**WELWYN HATFIELD BOROUGH COUNCIL  
EXECUTIVE DIRECTOR - PLANNING, PUBLIC PROTECTION AND GOVERNANCE**

**DELEGATED APPLICATION**

**Application No:** 6/2021/3267/HOUSE  
**Location:** 379 St Albans Road West Hatfield AL10 9RU  
**Proposal:** Erection of a single storey rear extension, a two storey front/rear/side extension, extension to roof and insertion of 1 x rear dormer  
**Officer:** Ms Kirsty Shirley

SCALE	1:100 @ A3
DATE	20210721
DRAWN	SDJ
DRAWING No	501

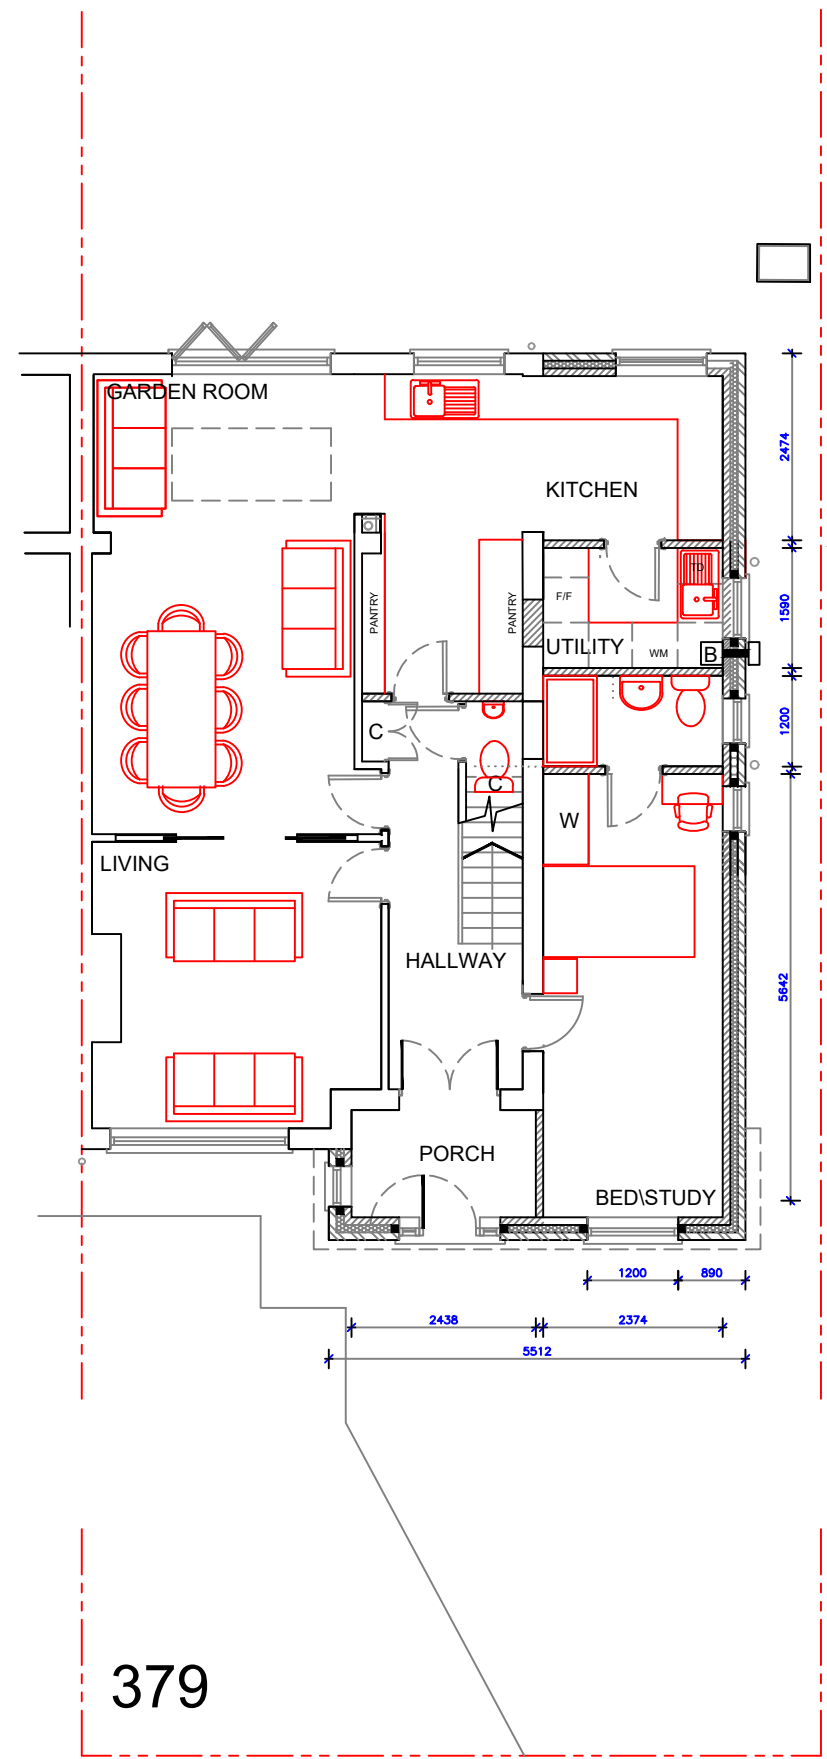
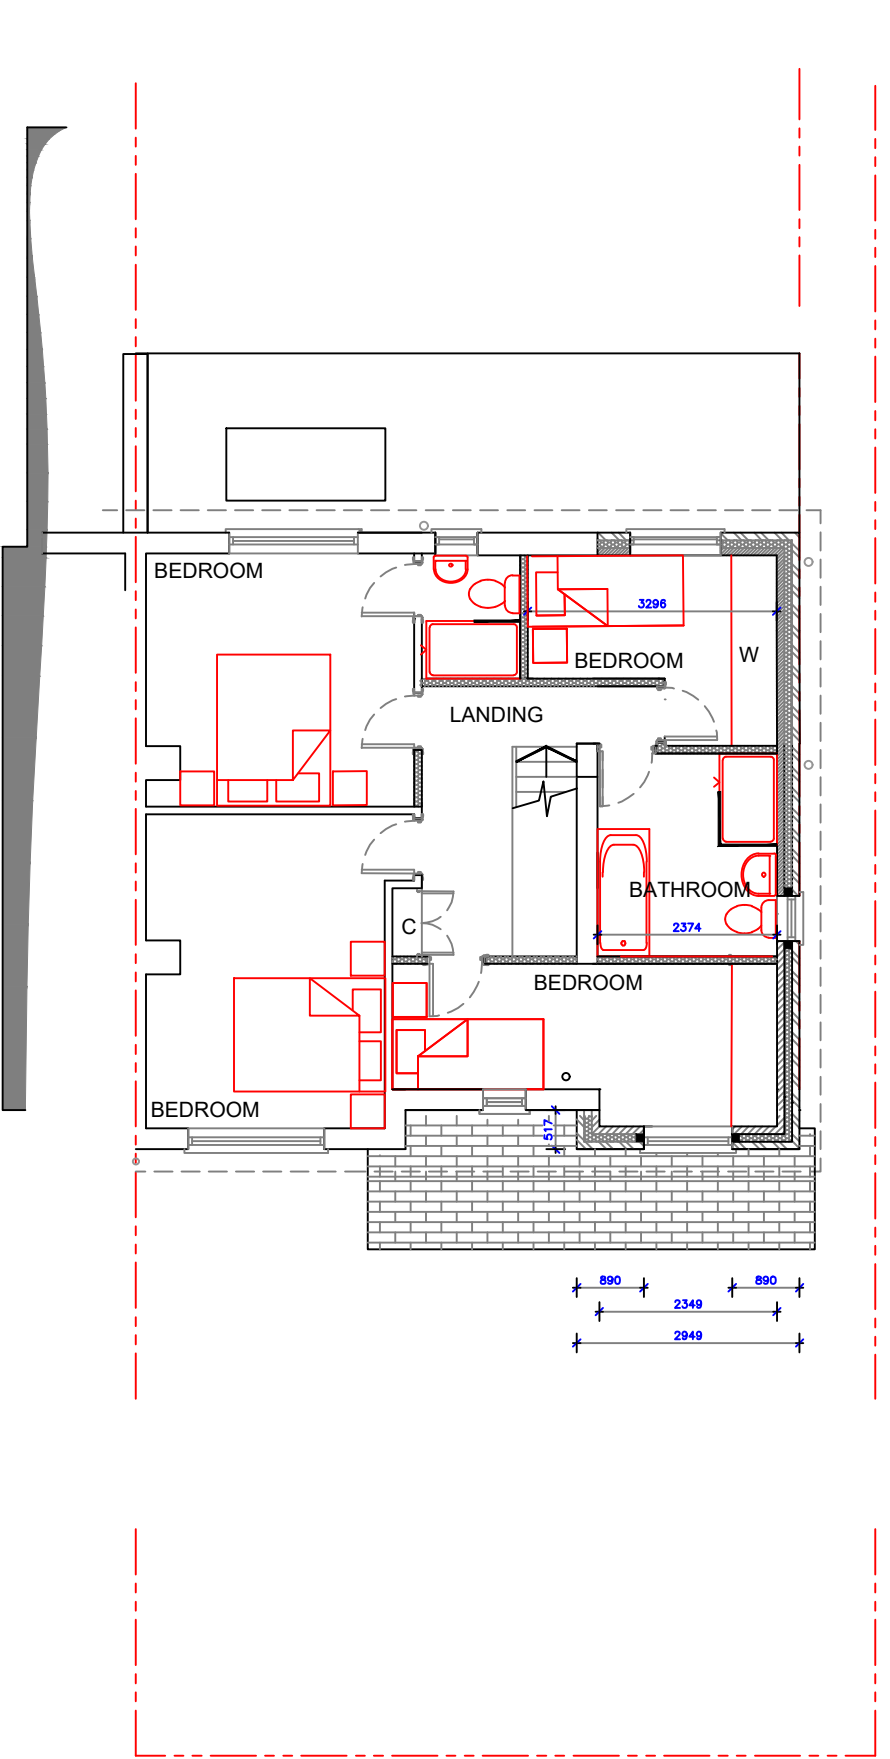
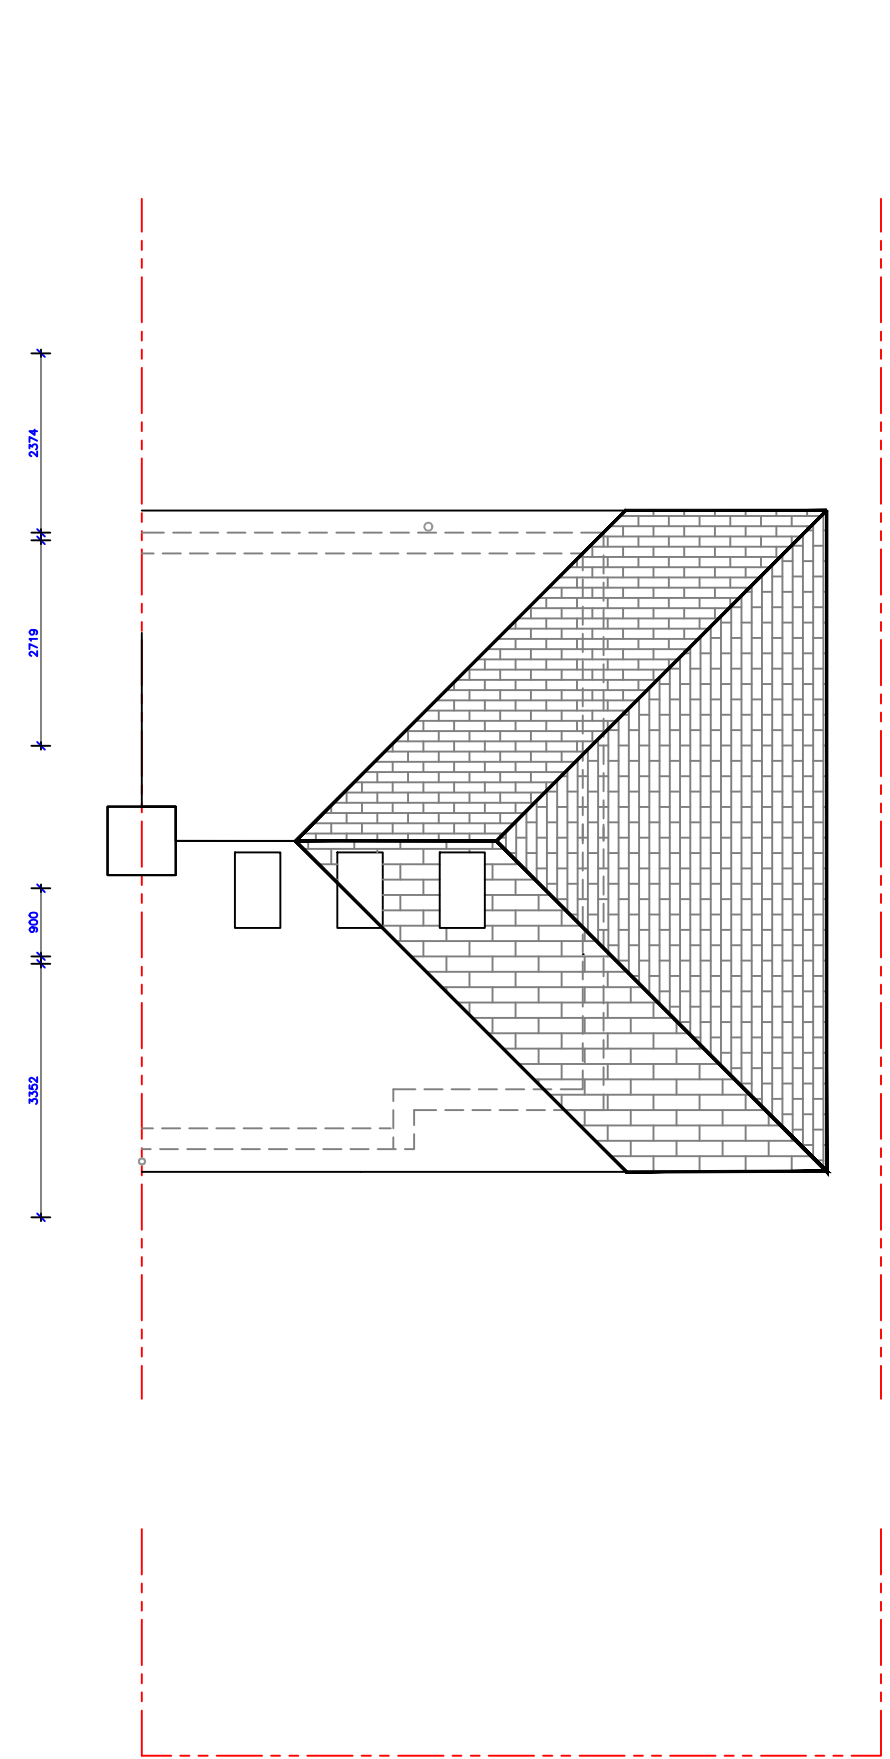
**Comment** (if applicable): The proposal would increase the amount of bedrooms spaces from three to four, as well as resulting in the loss of the garage. The Council's Car Parking Guidance advises four or more bedroom dwellings in this location should provide three car parking spaces.

The front of the property already benefits from a large area of hardstanding at the front that allows for the parking of at least three vehicles. Furthermore, the size of the existing garage falls below the minimum space dimensions set out in Council's Interim Parking Standard and is considered inadequately sized for many modern cars. It is considered that the proposed development would allow for adequate parking in line with the Council's Car Parking Guidance.

| DRAWING No | 502 |

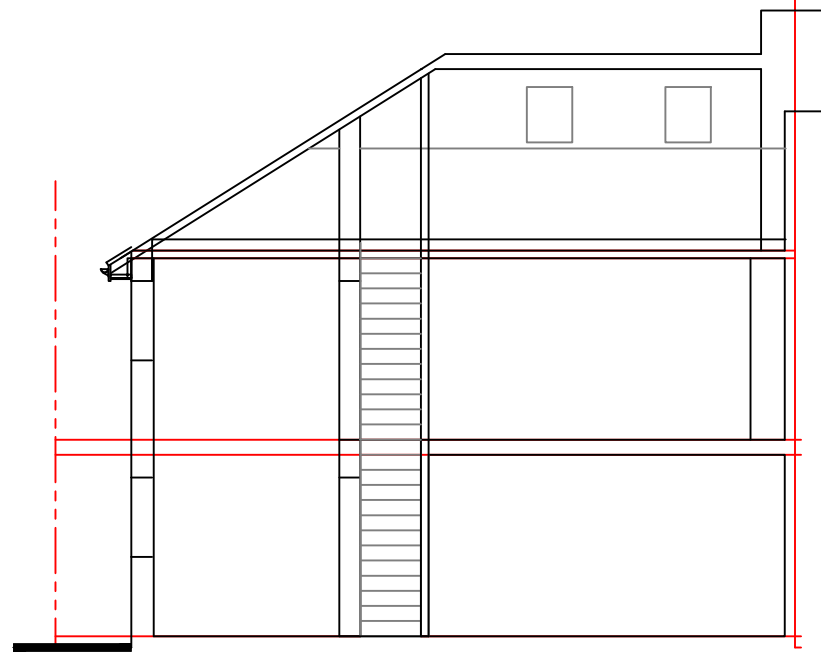
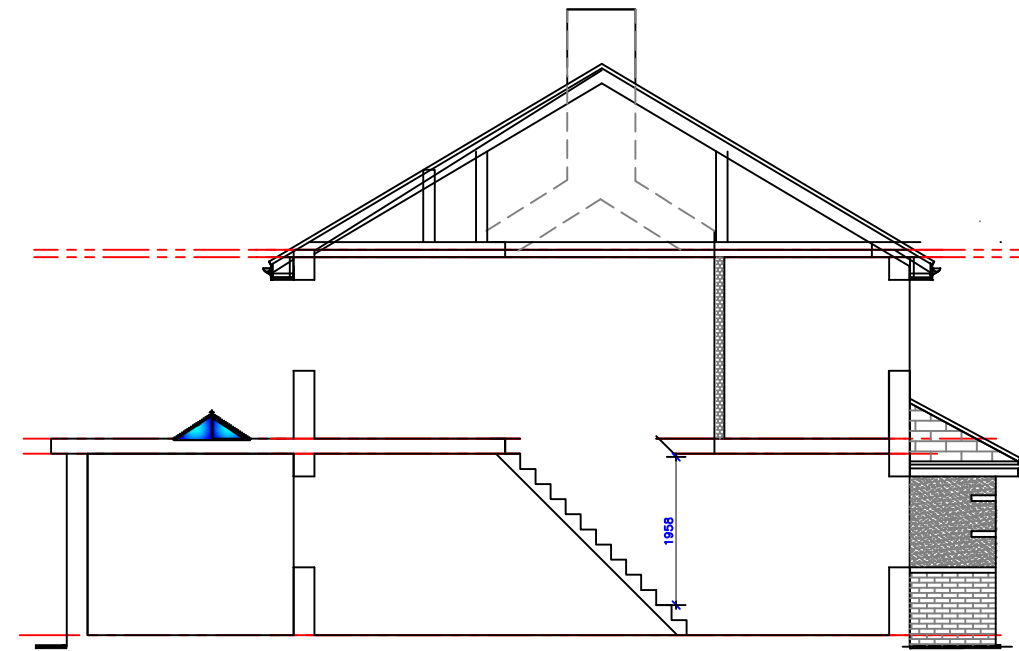
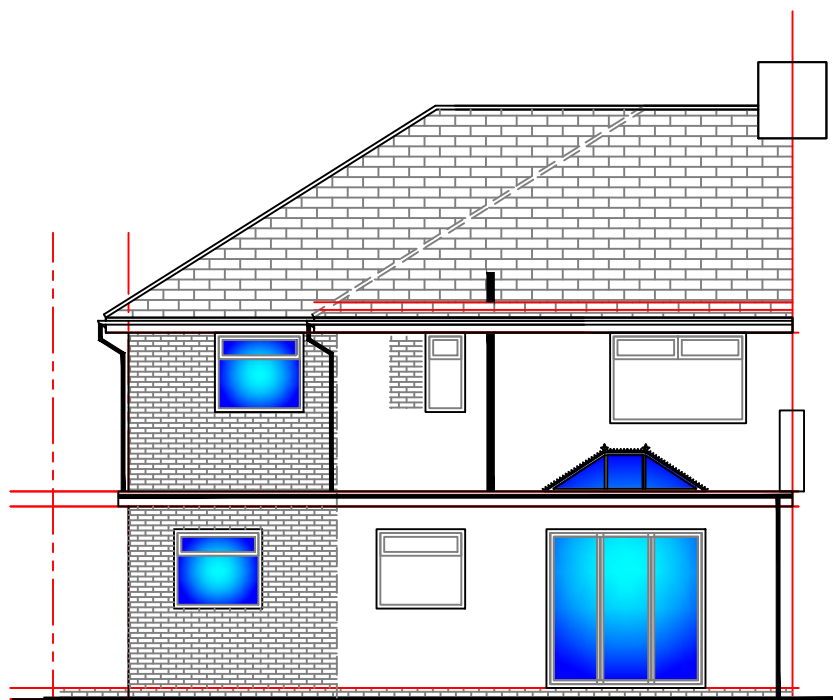
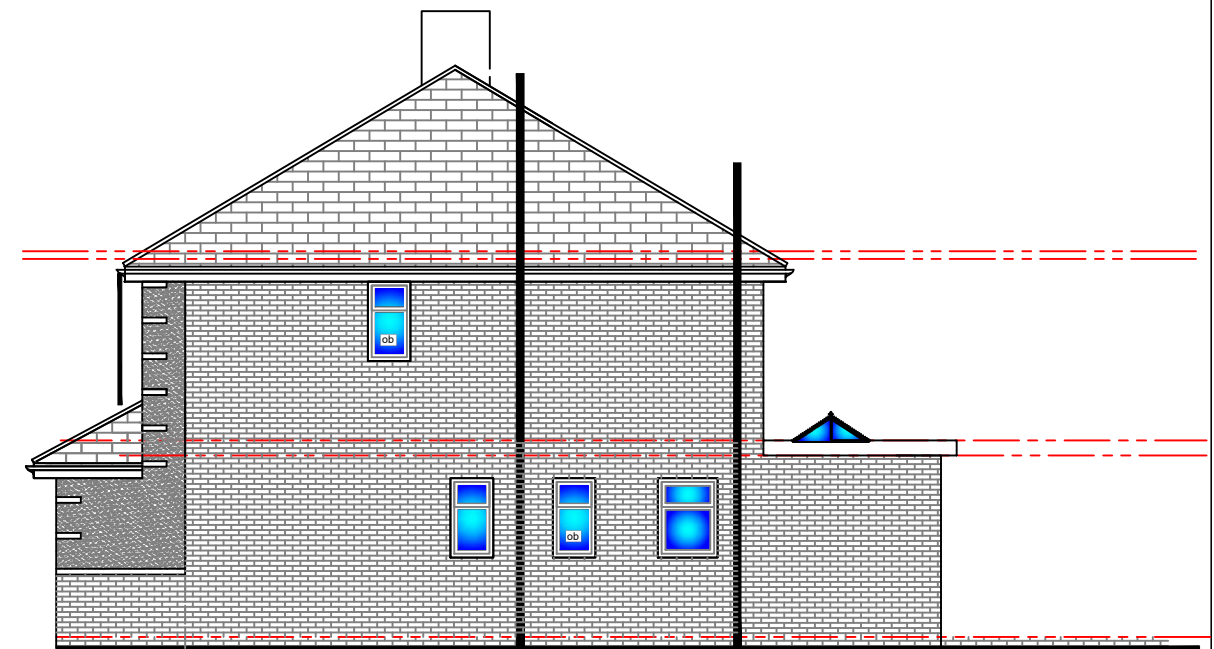
The two storey side extension would maintain a 1m separation distance from the adjoining boundary in line with the Council's Supplementary Design Guidance. Although the two storey side extension would be a substantial addition to the dwelling, the hipped roof would be in keeping with the existing roof and would limit the bulk and massing of the addition, ensuring the two storey side extension would not overwhelm or appear unduly dominant towards the application dwelling.

Three rooflights are inserted into the front roof slope. The rooflights are positioned equidistantly within the roof slope and the size and scale of the roof lights would not overwhelm the roof slope.

The proposed single storey front extension would extend across approximately two thirds of the front elevation, and the front extension's size, scale and positioning would appear subservient to the existing dwelling. The front extension would feature a hipped roof which would be in keeping with the application dwelling and wider street scene. The proposed rear infill extension would finish in line with the existing rear elevation and create a cohesive footprint.

The proposed windows are moderate in size and scale, and the positioning of the windows within the elevations of the property would not result in adjoining neighbours to experience a detrimental loss of privacy. In regards to sunlight and outlook, it is considered the positioning, size and scale of the proposal would not result in a detrimental loss of light to adjoining neighbours, nor would the development appear unduly dominant.
